Date: 09-Jul-2026
Our Ref: 2026/90201

**PRIOR APPROVAL FOR ALTERATIONS TO BRIDGE BRIDGE MVL3/67 LOW
WESTWOOD LANE, NORTH OF LINTHWAITE (WITHIN A CONSERVATION AREA)
LOW WESTWOOD LANE, HUDDERSFIELD, HD7 4EW
APPLICATION NO: 2026/90201**

Drawing Title  
**Prior Approval - MVL3/67 Low Westwood Lane - Existing and Proposed Elevation and Section**

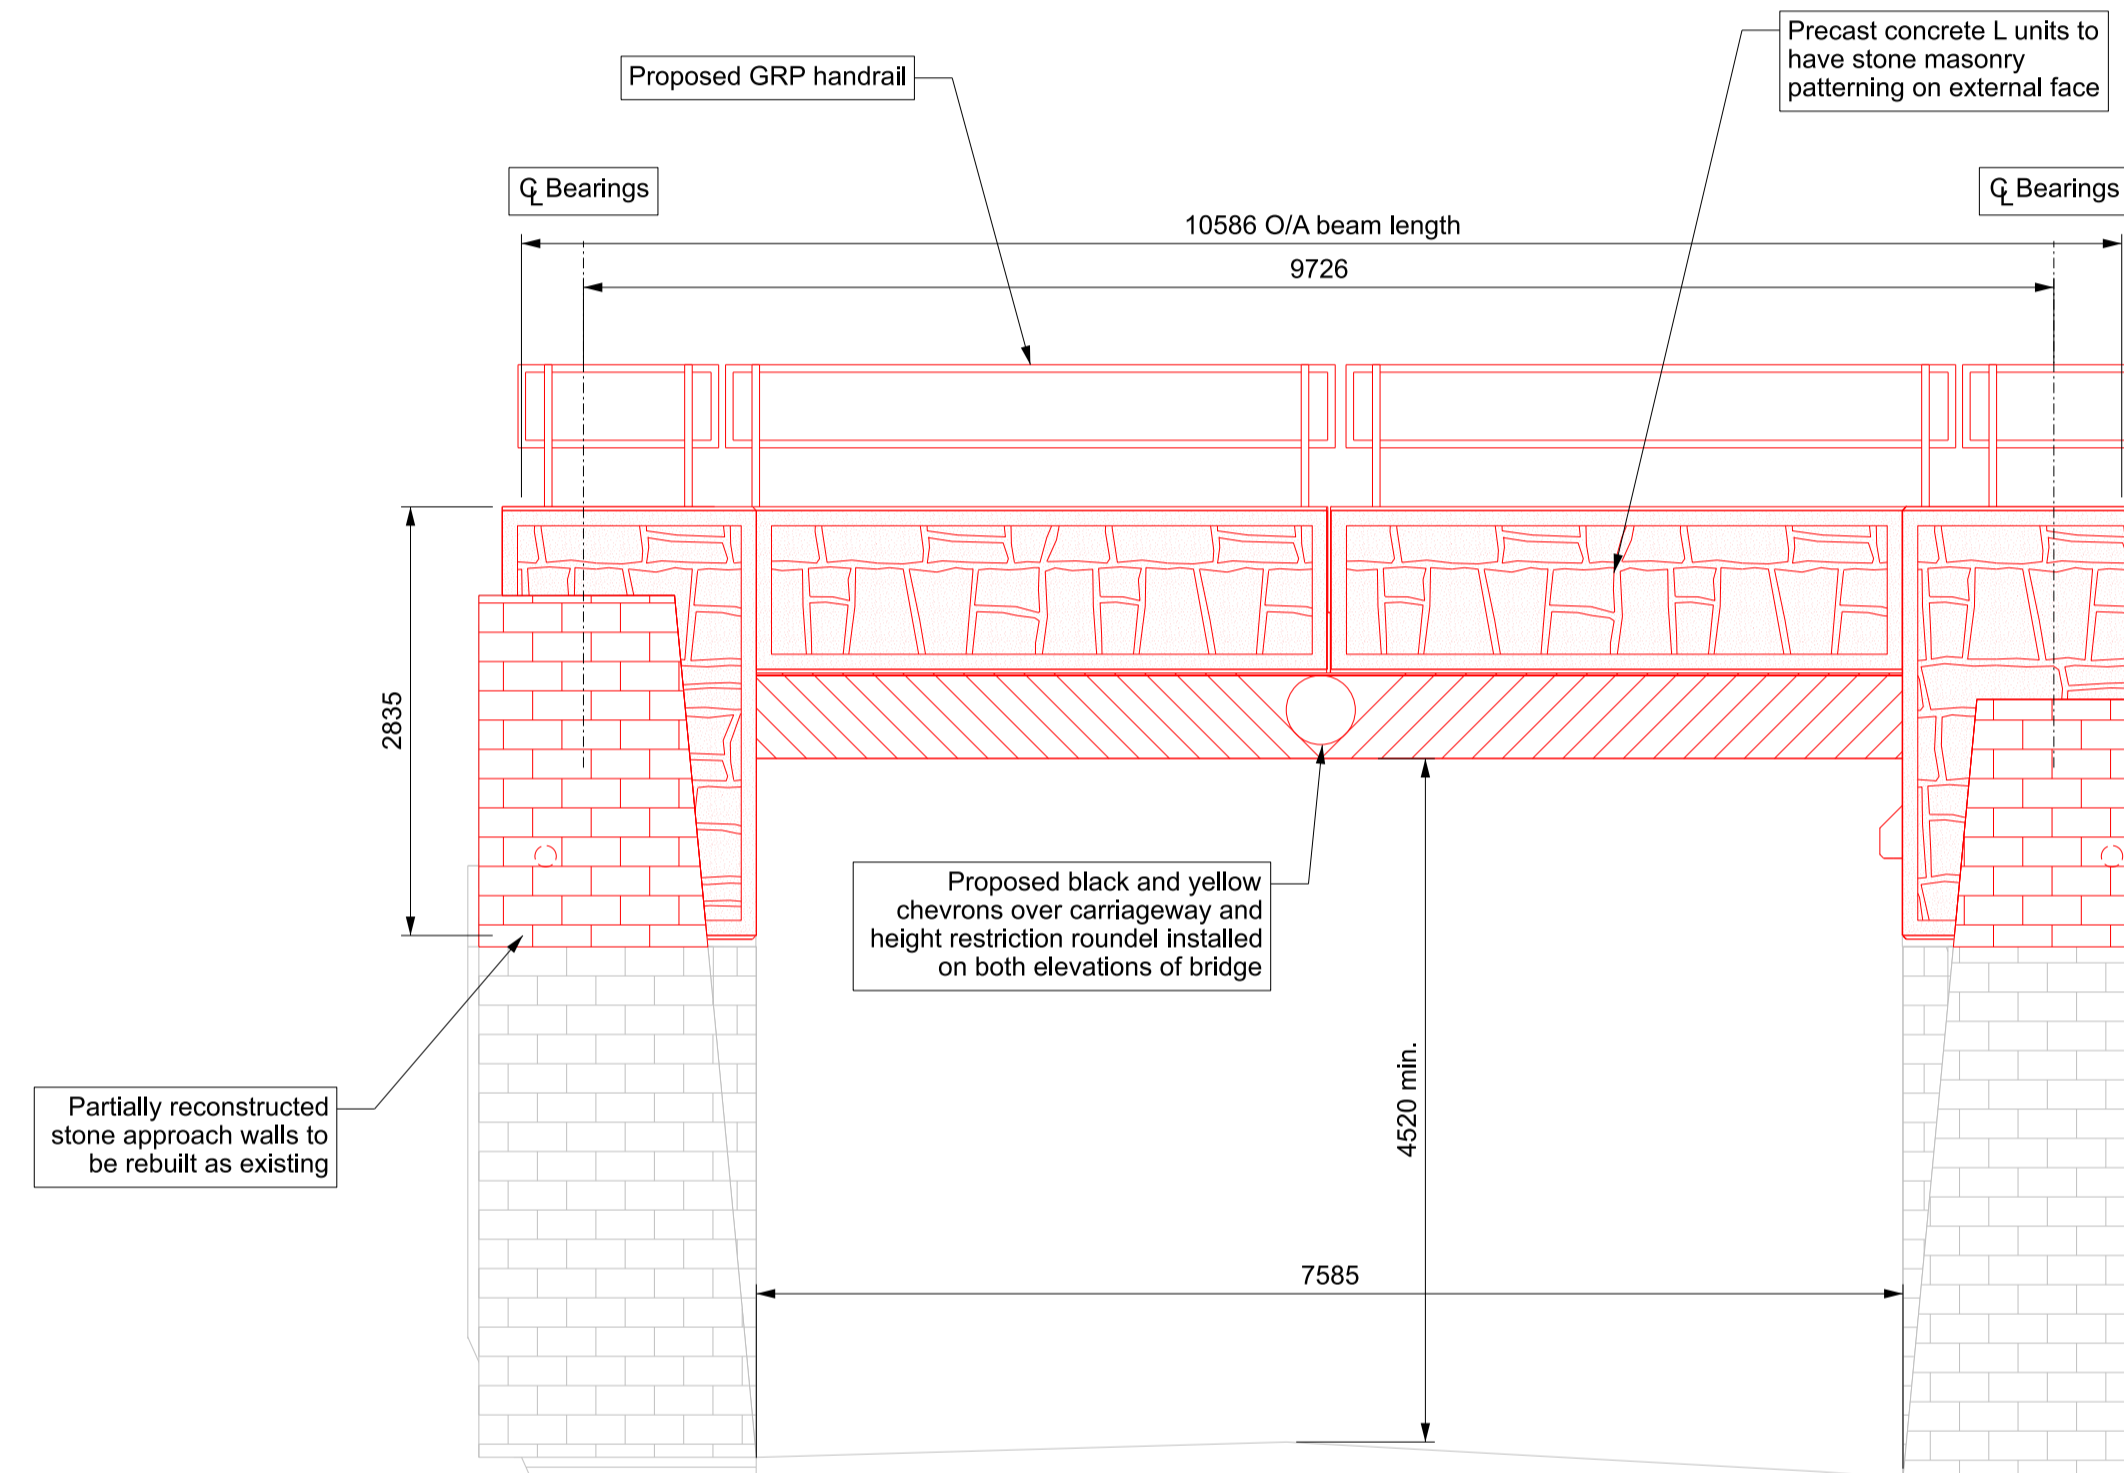
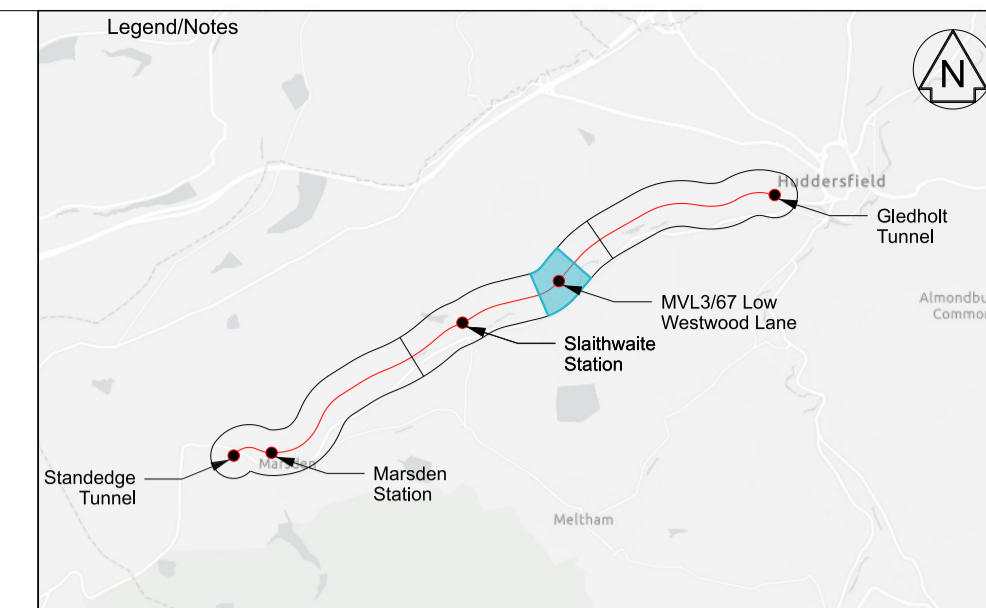
1. Notwithstanding the submitted plans, a sample of the parapet finish[es] shall be submitted to and approved by the Local Planning Authority, prior to their installation. The external treatment of the parapet finish[es] shall reflect the retained stonework of the bridge in terms of colour, texture, finish and coursing.

2. The GRP handrail shall be finished in a black or green powder coating.
